Application No: H11-0418-25 **Applicant:** Seagate Homes

Proposal: Details of Construction Method Statement (Condition 3 of H11-0842-23)

Location: Land Off Lime Walk Long Sutton Spalding

Drawing Number: LWLS-SH-PD-CMP-1020 A

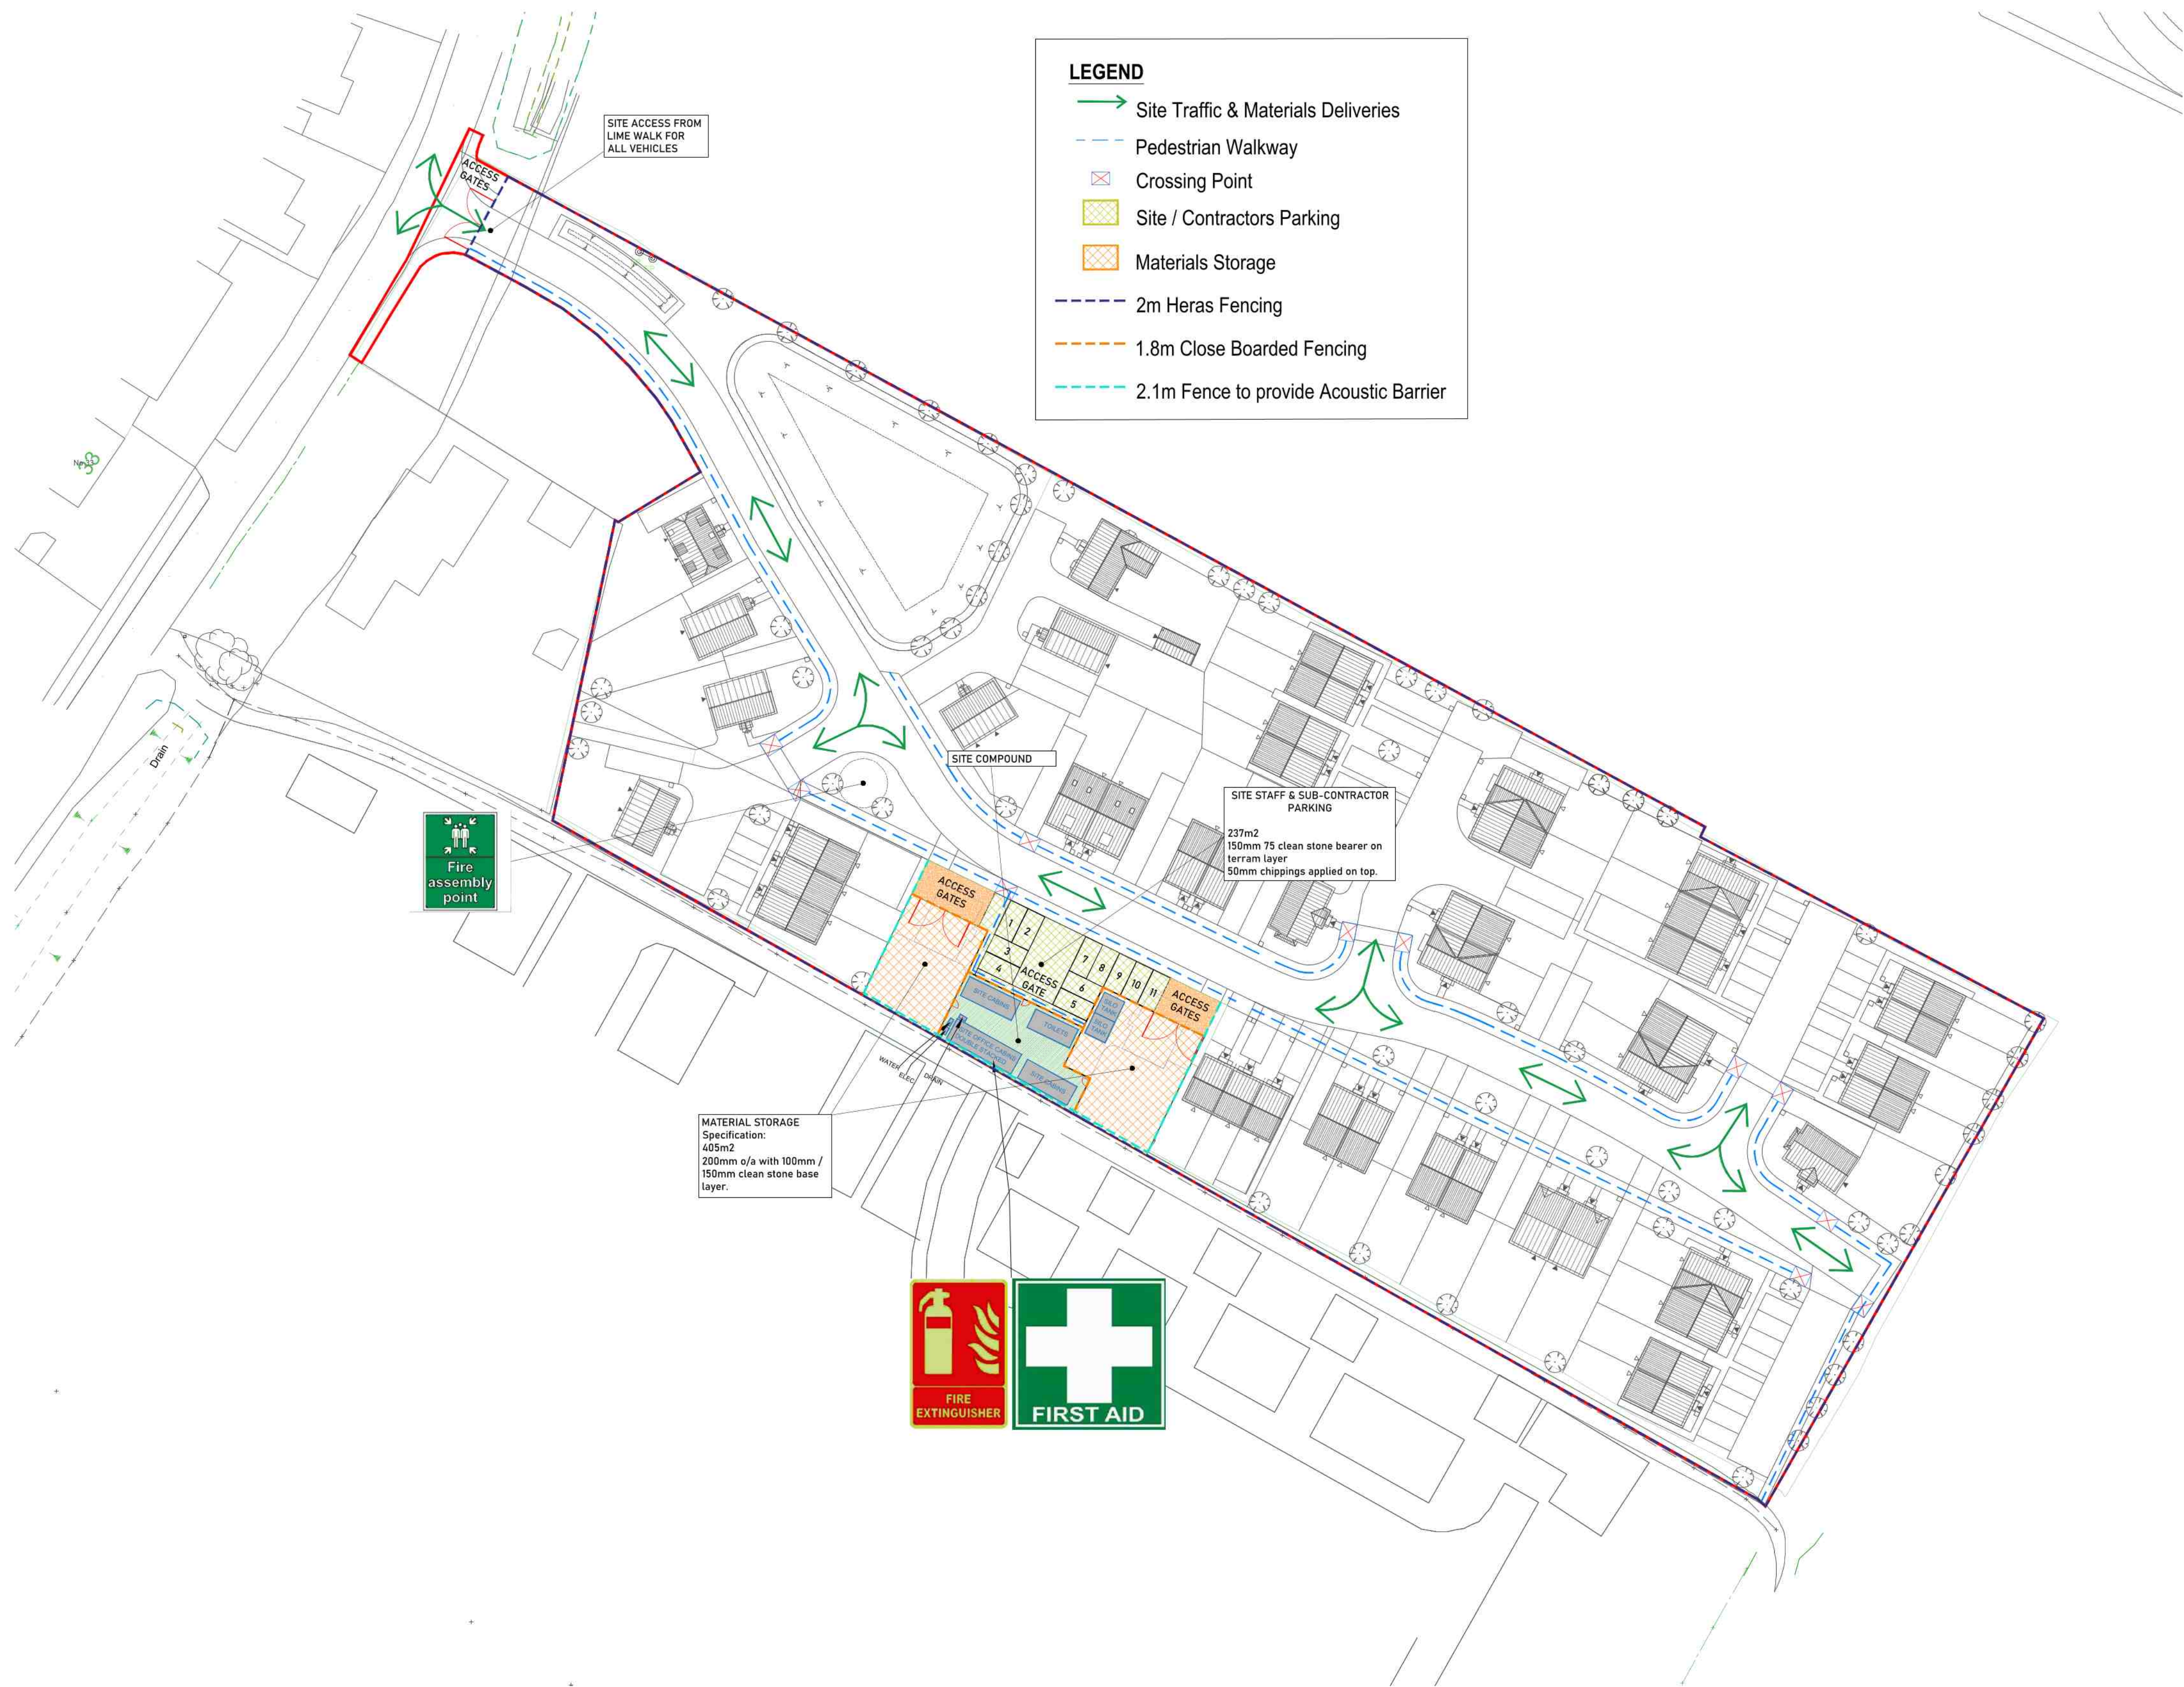
Advise, ensure appropriate screening is used for material storage compounds to reduce noise and dust to adjacent occupied properties.

The Environmental Protection Officer has advised that appropriate screening is required to the material storage compounds to reduce the effect on existing neighbouring properties, in terms of noise and dust. In response to this request the applicant has submitted a revised Construction Management Plan, which shows the provision of a 1.8metre close boarded fence around the boundary of the site/ contractor parking and the construction of a 2.1metres high fence to provide an acoustic barrier to the boundaries of the material storage compounds. It is considered that these measures will minimise the effect on existing residential occupants in terms of unacceptable levels of noise and dust during the construction phase.
